From: Amanda Scholes on behalf of Planning.Responses
Sent: 09 August 2017 08:42
To: Planning Scanning
Subject: FW: Planning Consultation on Y/51/17/DOC

Condition no.3

APPLICATION **Y/51/17/DOC**

Description of Works: Application for approval of details reserved by conditions imposed under planning application Y/11/16/PL relating to Condition No. 3 (Surface water drainage details) & 4 (Schedule & samples materials and finishes for external walls and roofs)

CLIENT		PROJECT	
Reg Hawks		Yapton Free Church, Yapton	
TITLE			
Proposed Drainage and Construction Details			
DRAWN		DATE	
M Glasgow		Jun 2017	
ENGINEER		CHECKED	
T. Zajac		BS	
SCALE		PROJECT NO.	
		22815	
		DWG No. REV.	
		201	
As Shown @ A1

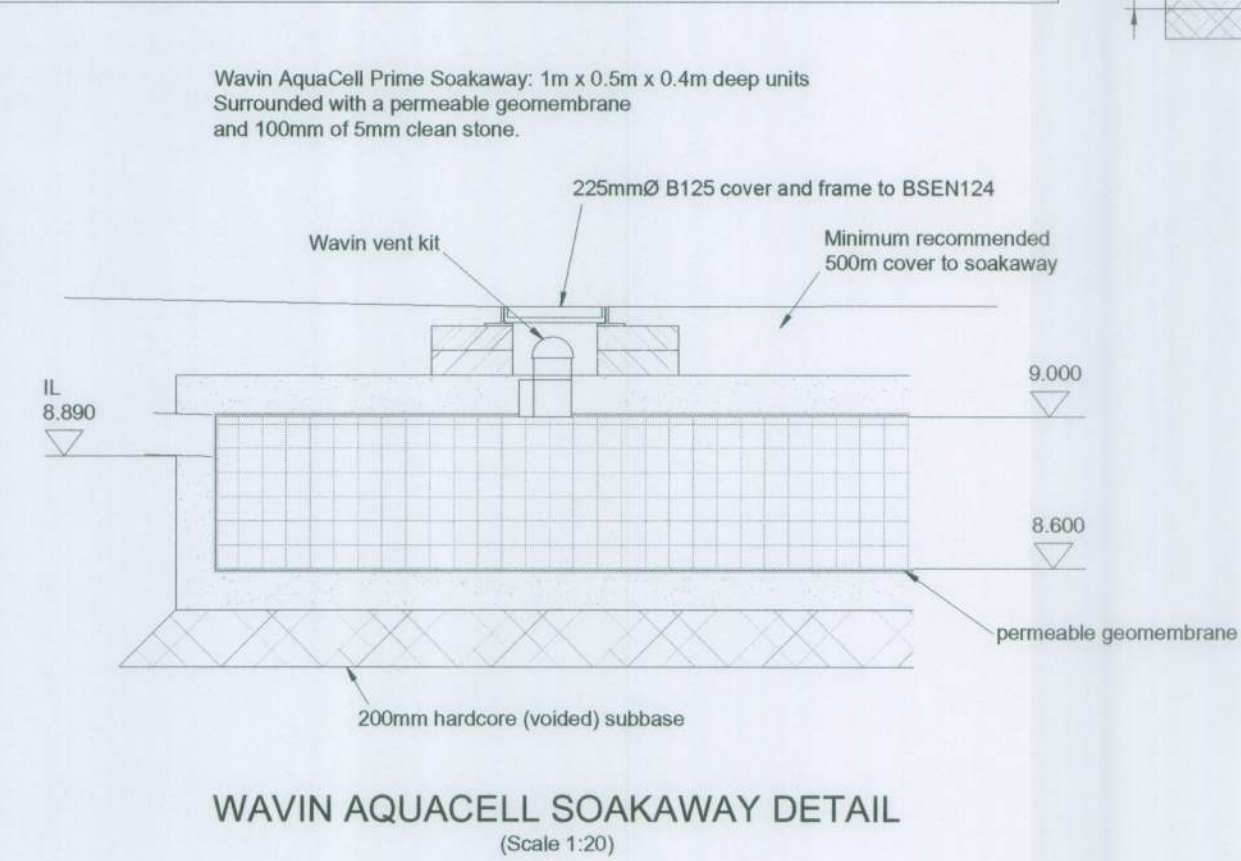
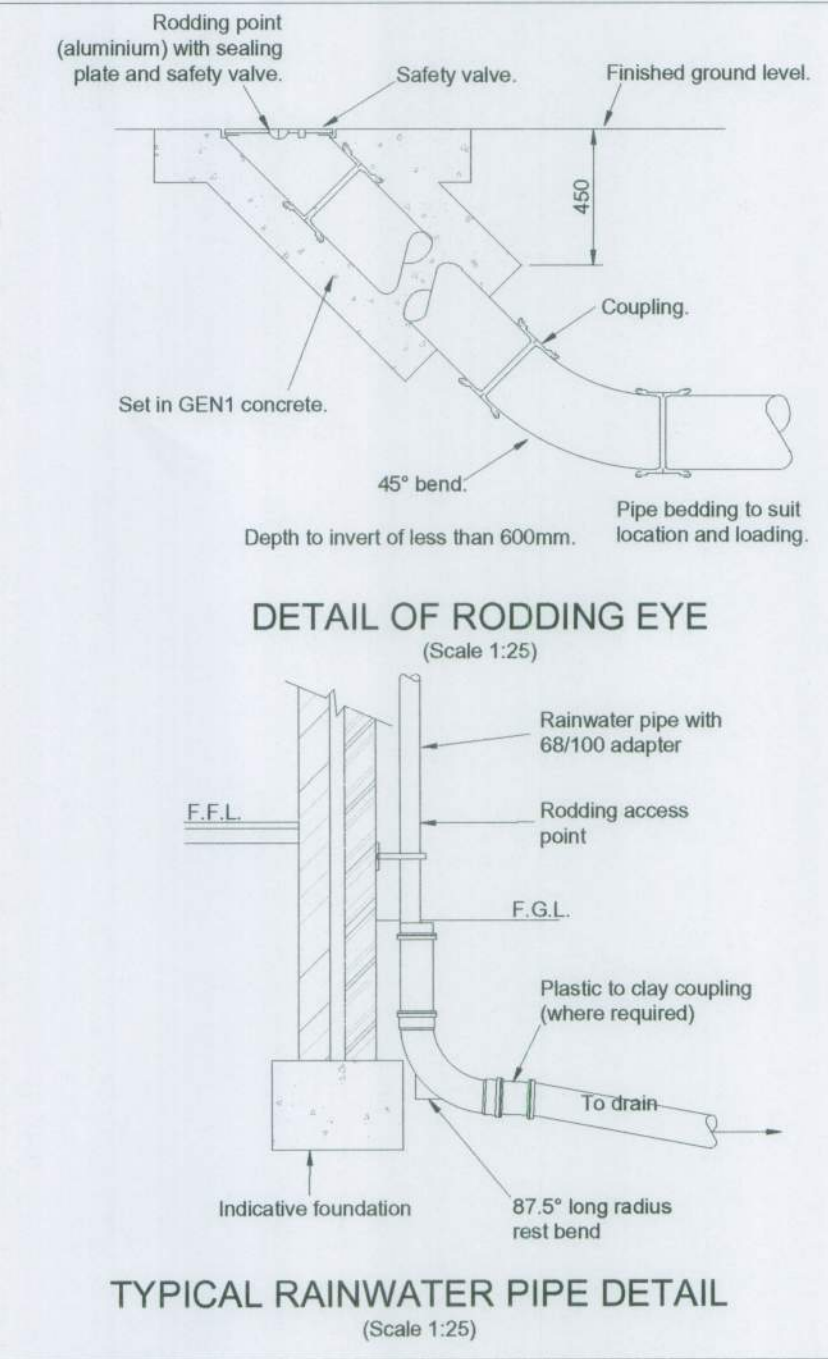
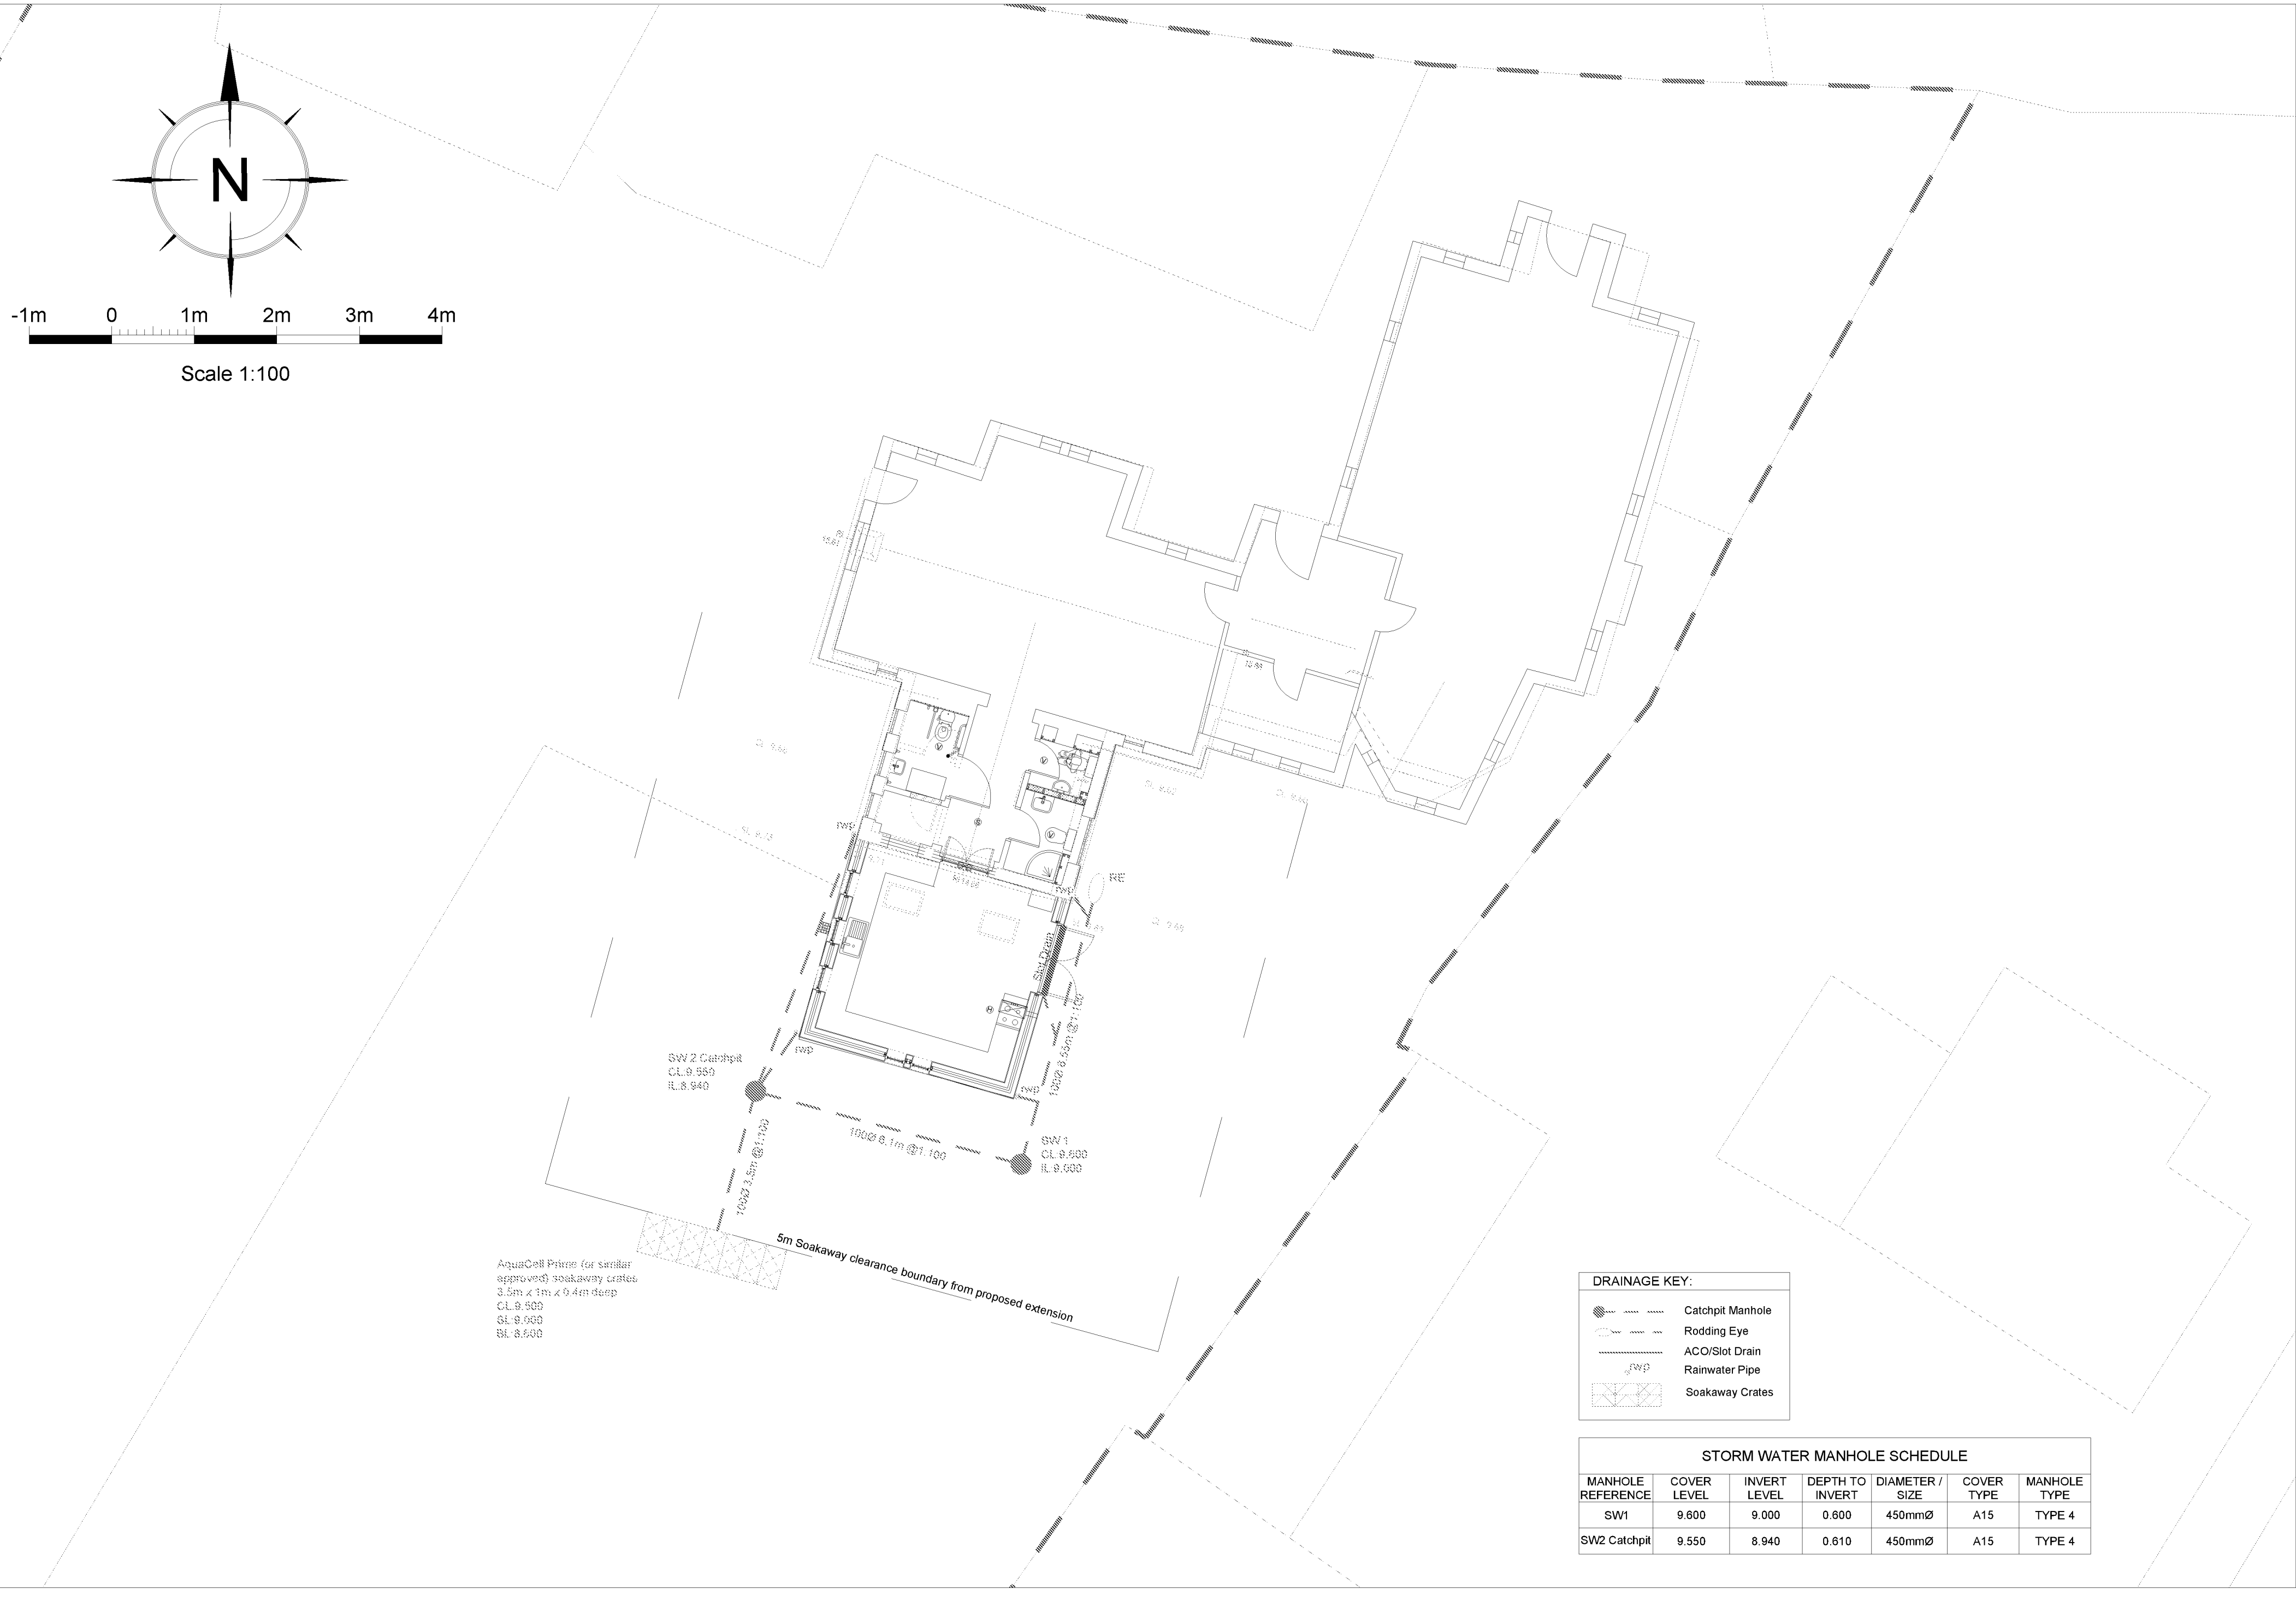
The applicant has not undertaken satisfactory winter groundwater monitoring to confirm peak levels, as the monitoring was carried out from the 8th March (end of winter) to 31st May 2017. The percolation testing has also not been carried out in the winter period (ie. June) and has not been carried out at the depth of the proposed structure.

Due to the locality, knowledge of the area and the scale of the development, and the fact that the proposed soakaway structure will be no greater than 900mm deep, I am prepared in this case to accept the groundwater data, however, a further percolation test (to BRE365) will be required 900mm deep at the location of the proposed soakaway.

The test results will then be compared to the other tests carried out and a safety applied to the result (to be agreed). Depending on the findings, It may be necessary to increase the size of the soakaway.
